***RE: BANK OF BELEN (G18-D42). ENGINEER'S CERTIFICATION FOR CERTIFICATE OF  
OCCUPANCY APPROVAL. ENGINEER'S STAMP DATED MAY 9, 1999.***

PROJECT TITLE: BANK OF BELEN ZONE ATLAS/DRNG. FILE: G-18-Z 042

**RE: *BANK OF BEL<sup>E</sup>AN (G18-D42). GRADING AND DRAINAGE PLAN FOR BUILDING PERMIT & SO-19 PERMIT APPROVALS. ENGINEER'S STAMP DATED November 24, 1998.***

## GRADING AND DRAINAGE PLAN

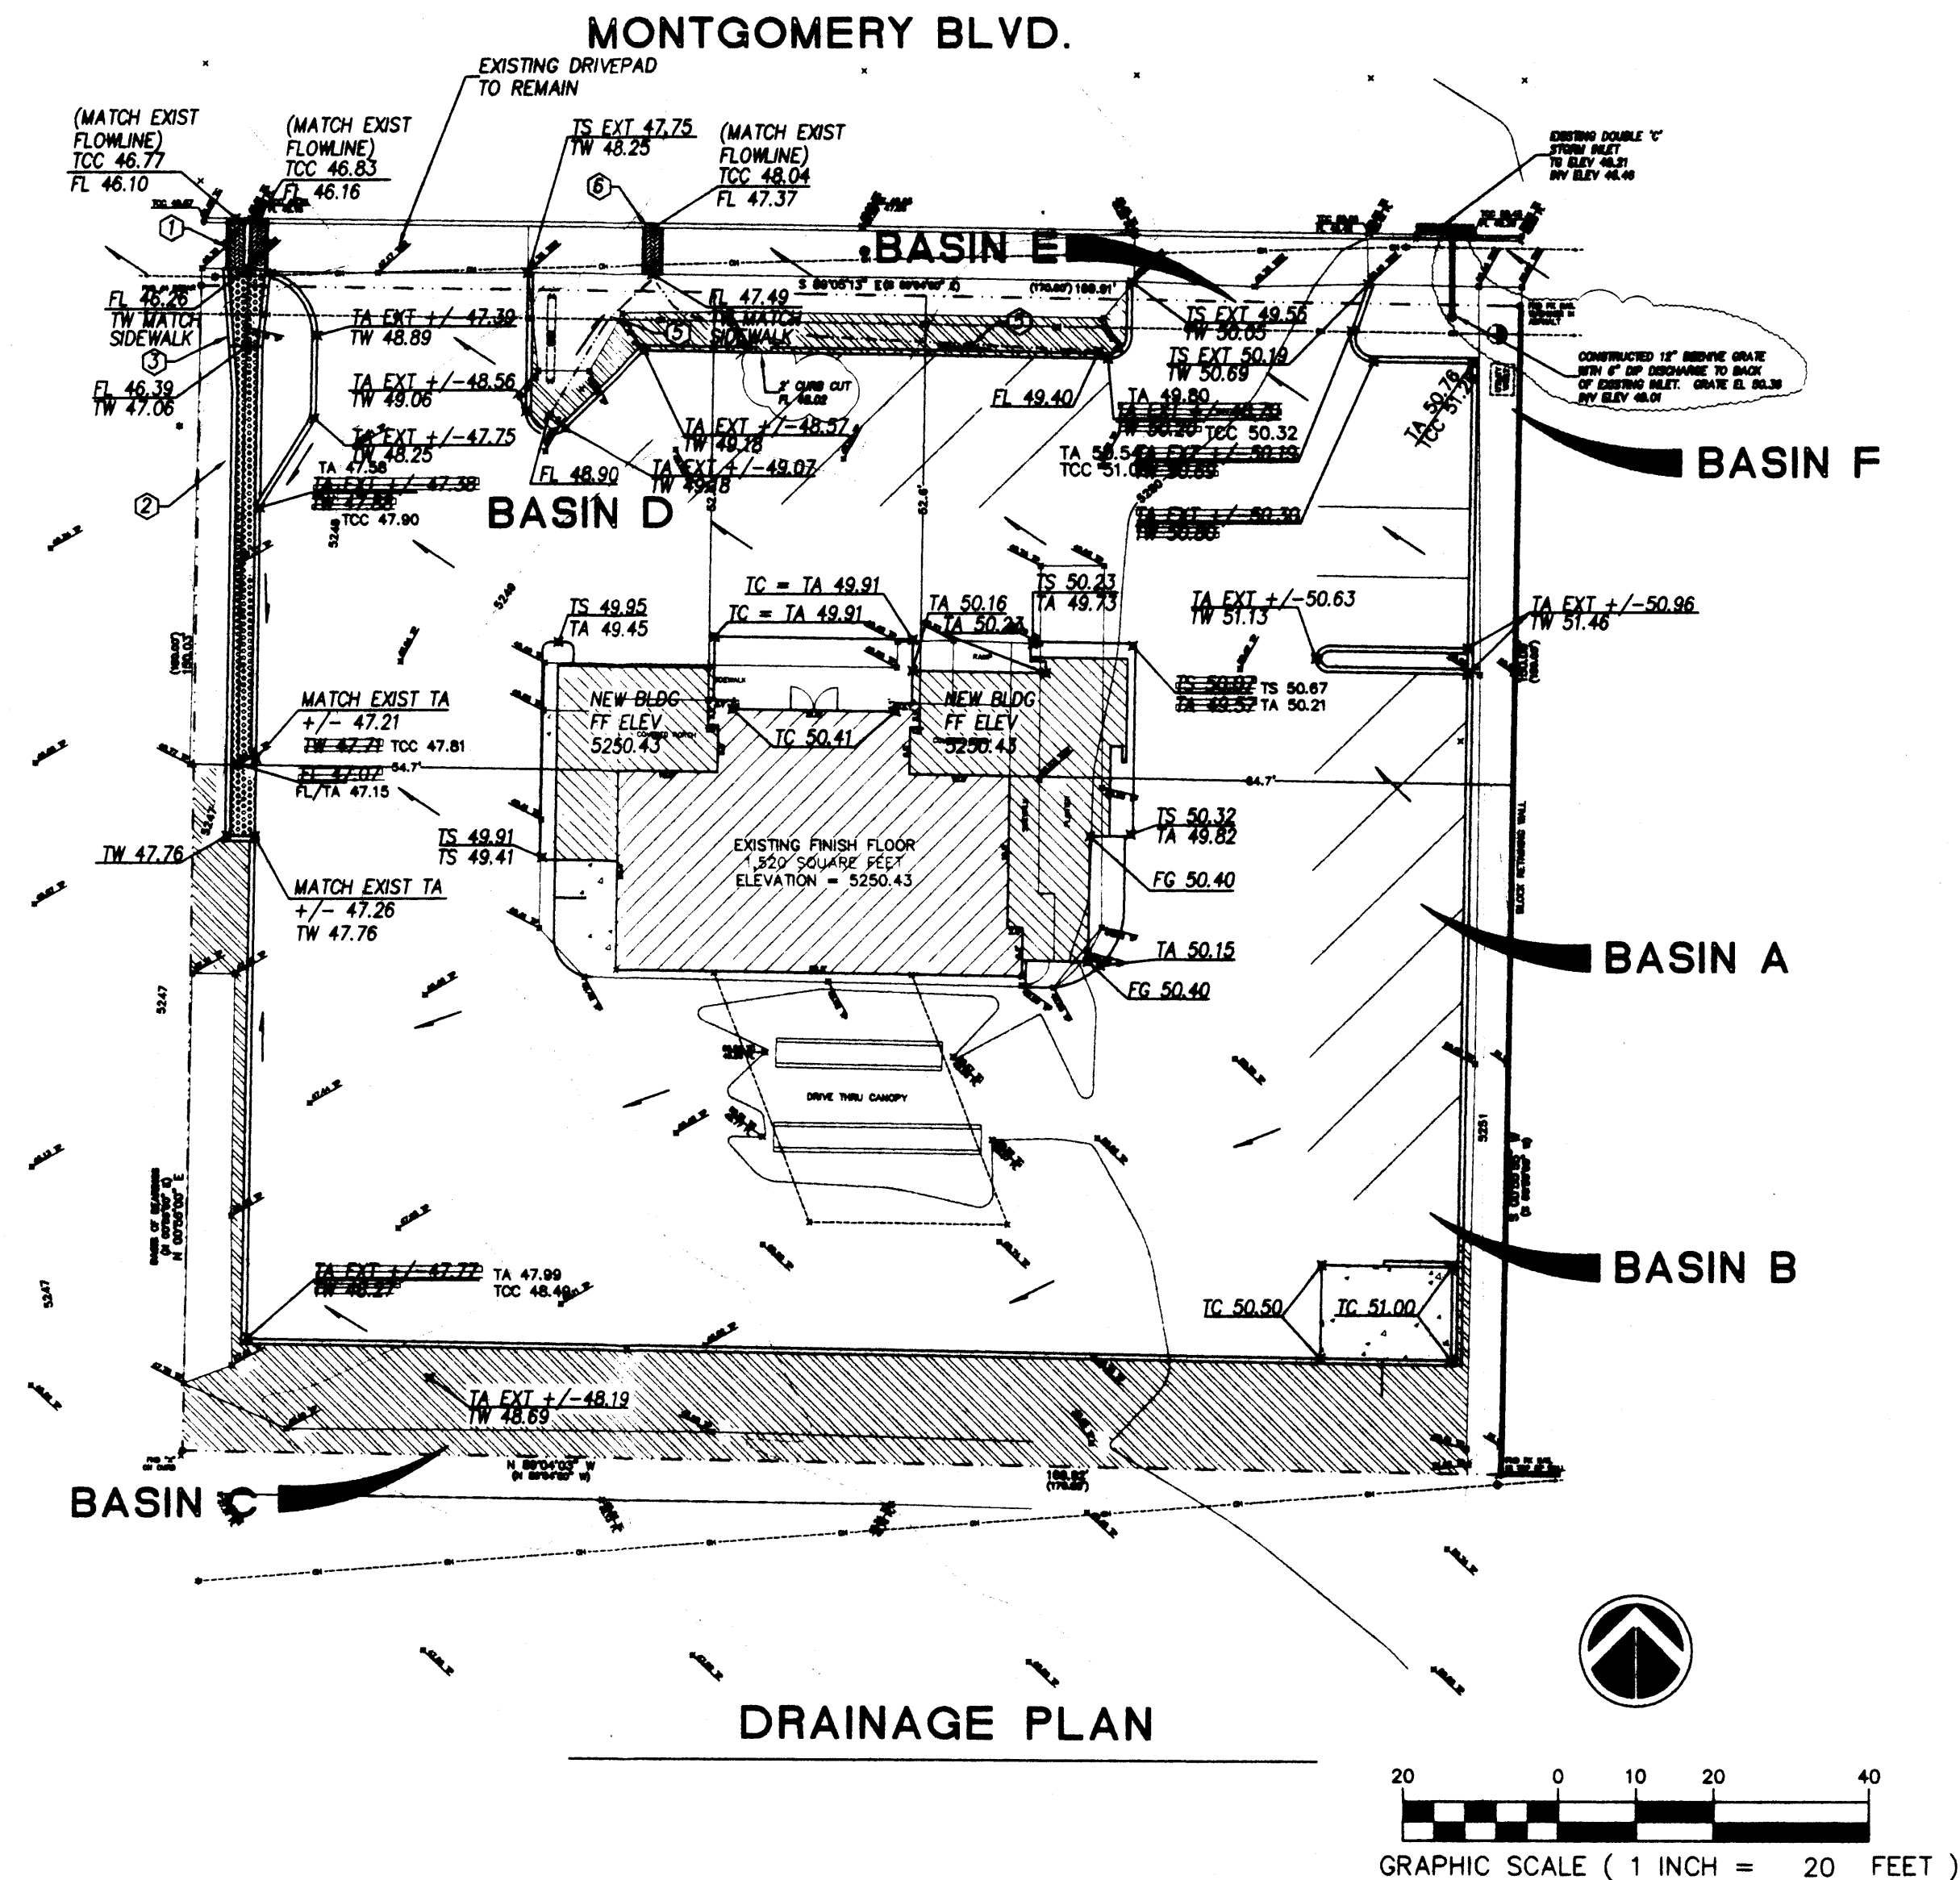
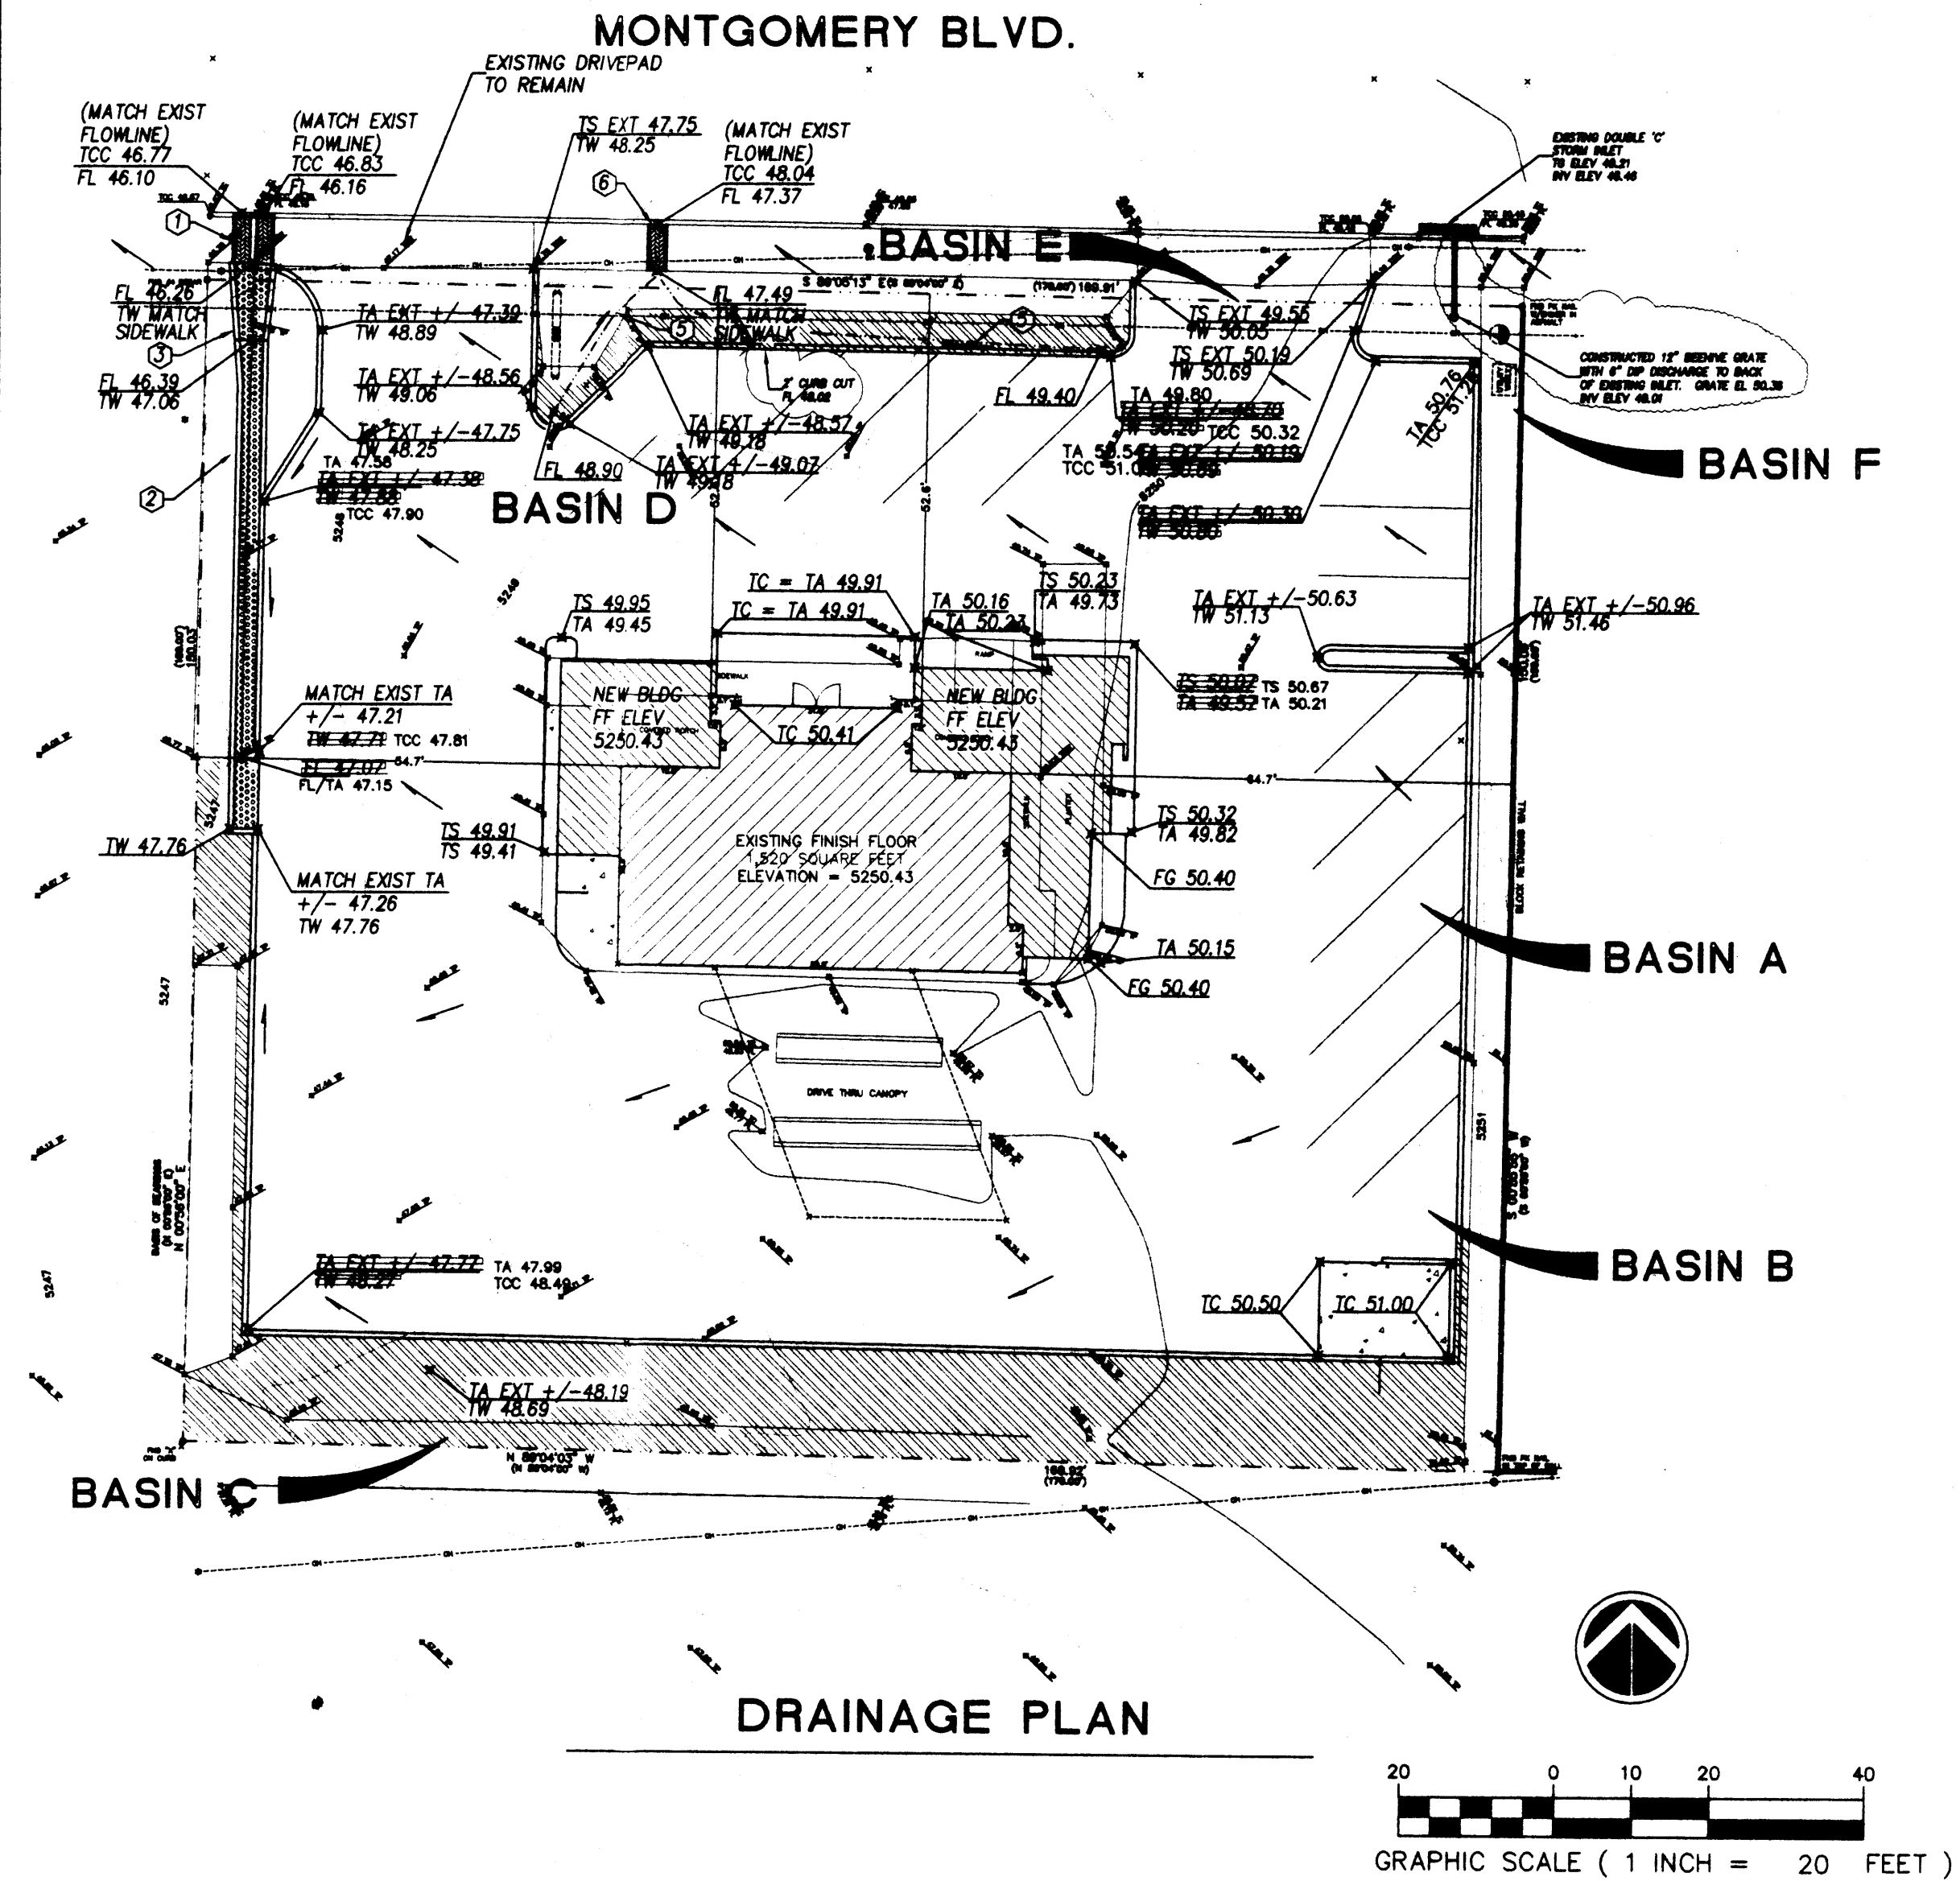
As discussed today, please highlight Montgomery, San Mateo, San Pedro and Madeira Streets on the Vicinity Map. On the Drainage Plan, highlight Montgomery Blvd. and identify new striping in parking lot.
